From: DaSilva, Luis [REDACTED]
Sent: 03 January 2018 16:38
To: Planning.Responses
Subject: planning application consultation - WA/80/17/HH

WA/80/17/HH

Proposal: Demolition of existing rear conservatory & erection of single storey rear flat roofed extension. This application may affect the character & appearance of the Walberton Green Conservation Area.

Site: 3 Homefield Crescent, Walberton, BN18 0PX.

DRAWING BLOCK PLAN DATE: NOVEMBER 2017 DRAWN: T. Murray	SCALE 1/500
DRAWING: 17/56/3	REVISION:

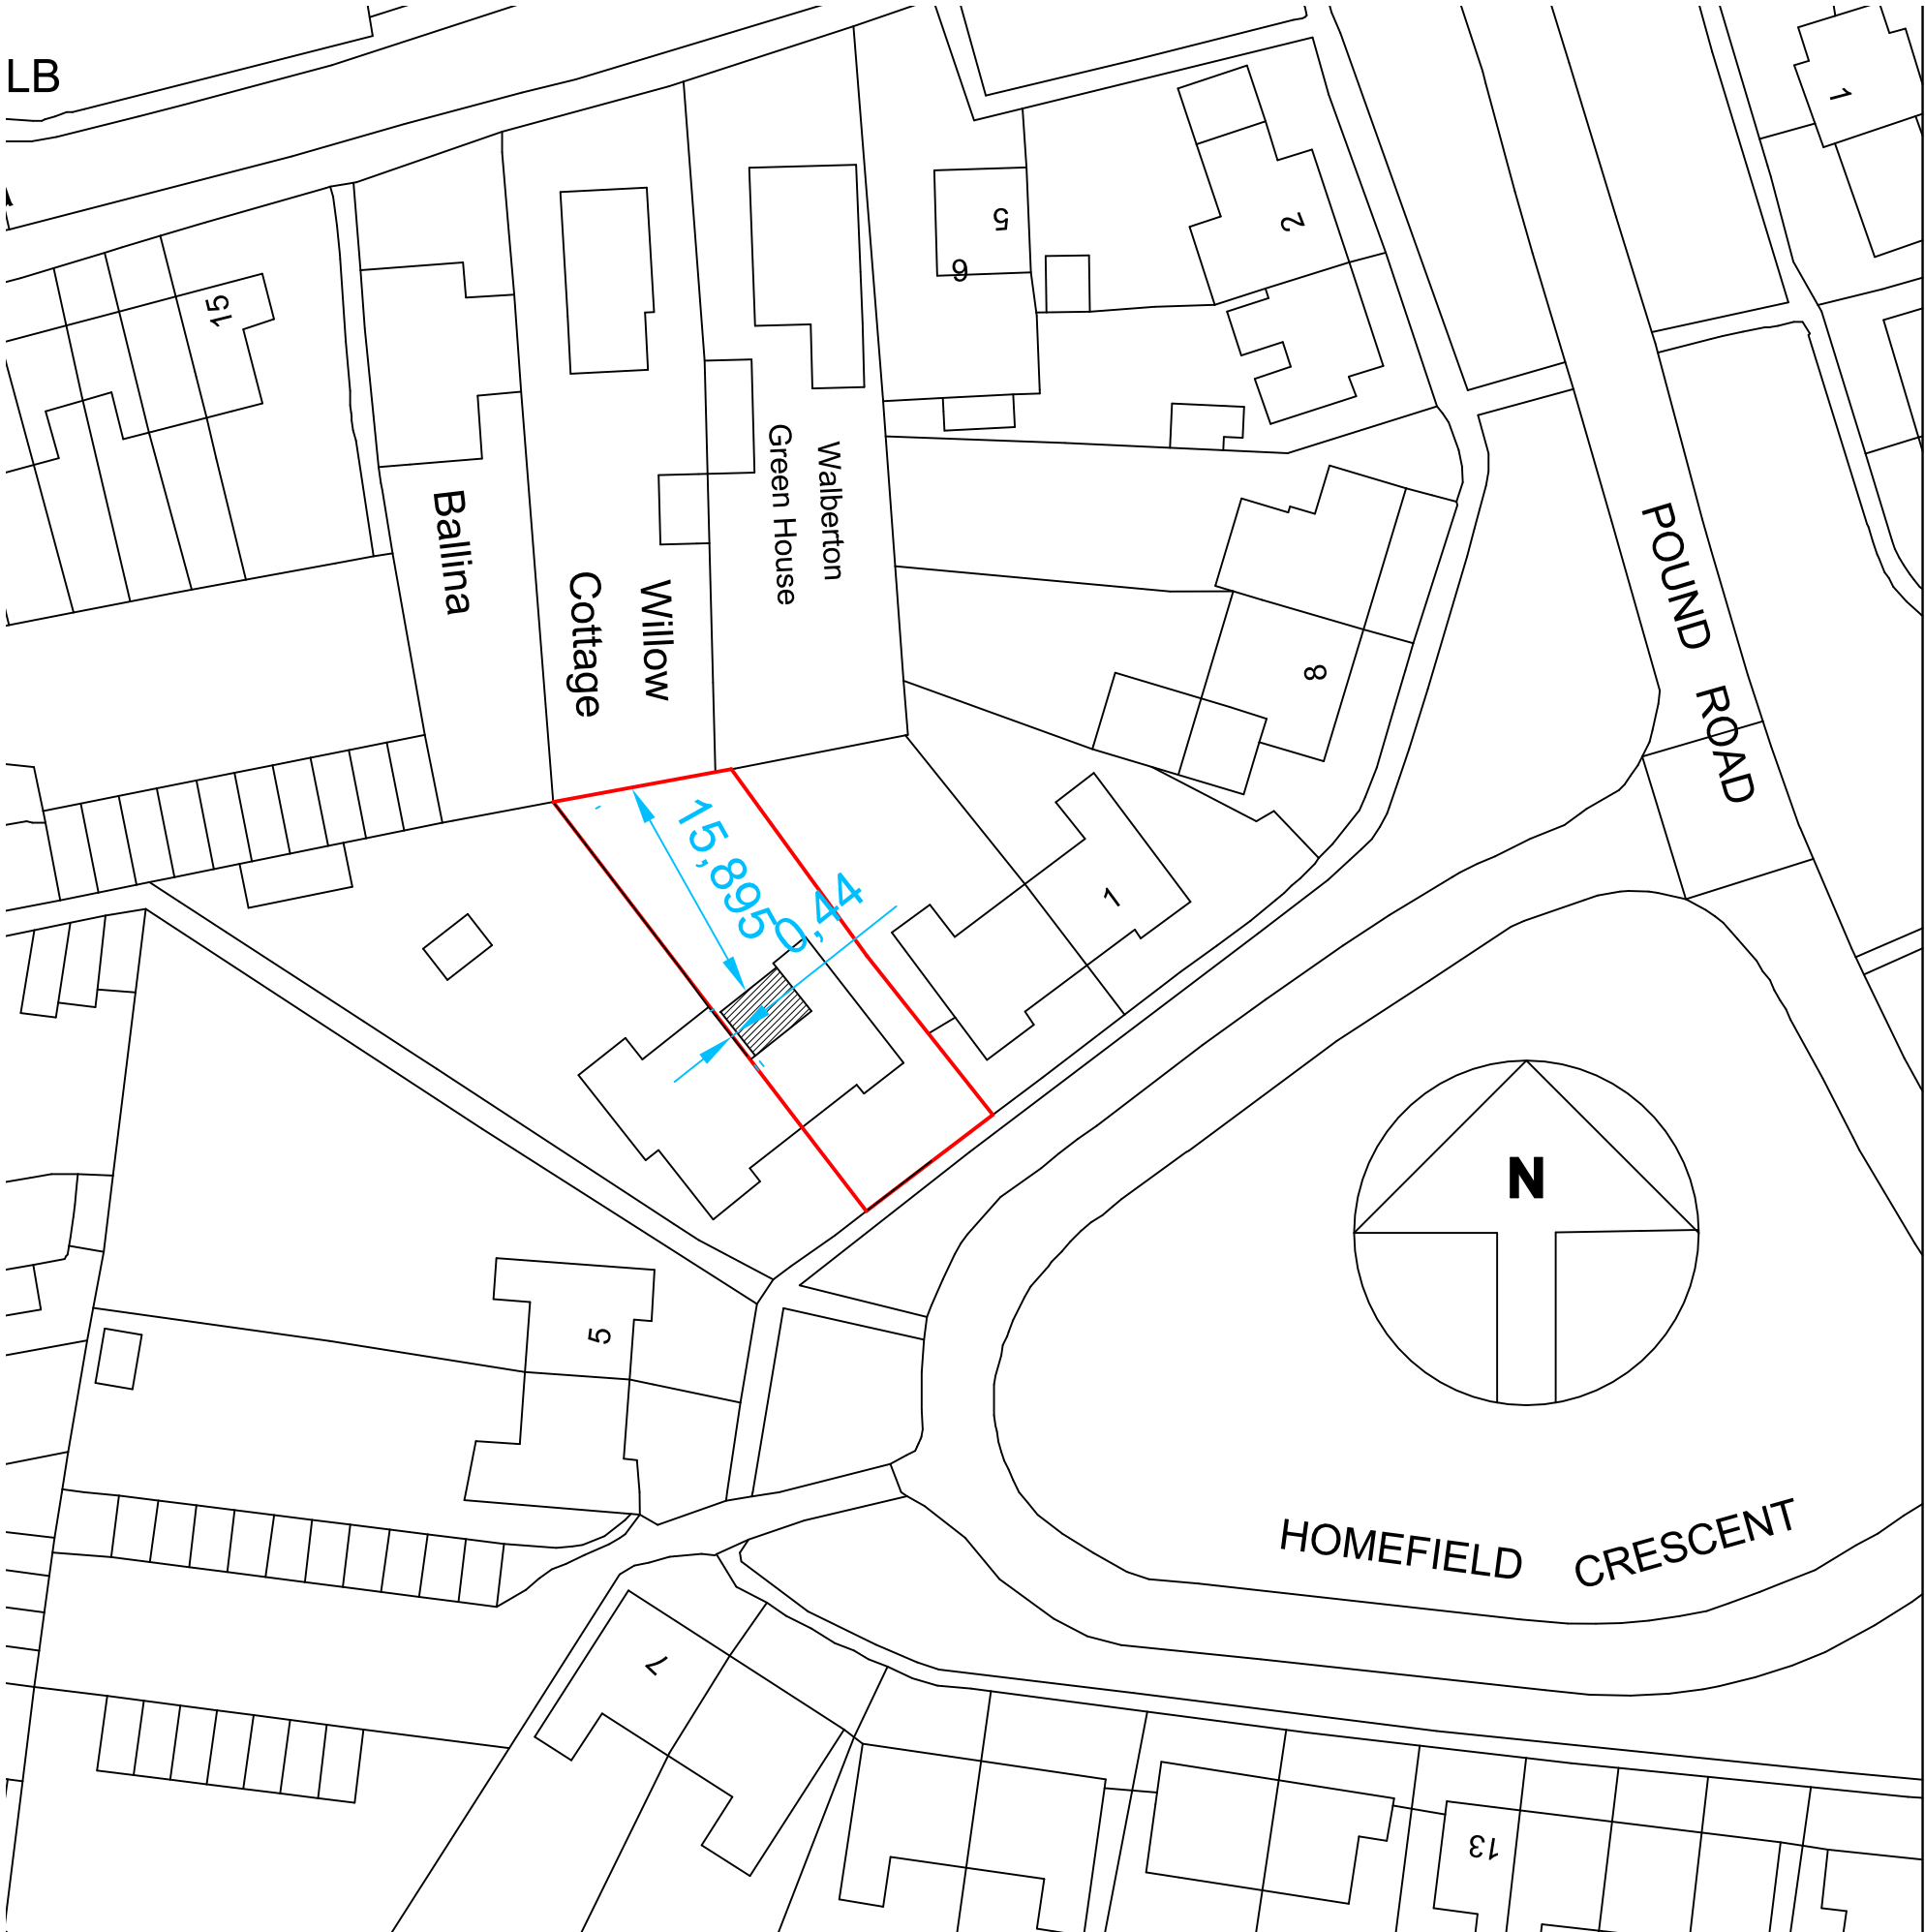
Please find attached a plan of the sewer records showing the approximate position of a public foul sewer crossing the site

It appears that the developer is intending to build close to a public foul sewer which is crossing the site. Building over a "public sewer" is not normally permitted by Southern Water.

However, under certain circumstances building over a sewer may be allowed. The conditions associated with the build over/close to a sewer are contained in Southern Water guidance notes which are available at: www.southernwater.co.uk. A formal application to build close to the sewer will required to be submitted by the applicant.

In order to protect drainage apparatus, Southern Water requests that if consent is granted, a condition is attached to the planning permission For example: "The developer must agree with Southern Water, prior to commencement of the development, the measures to be undertaken to protect the public sewer."
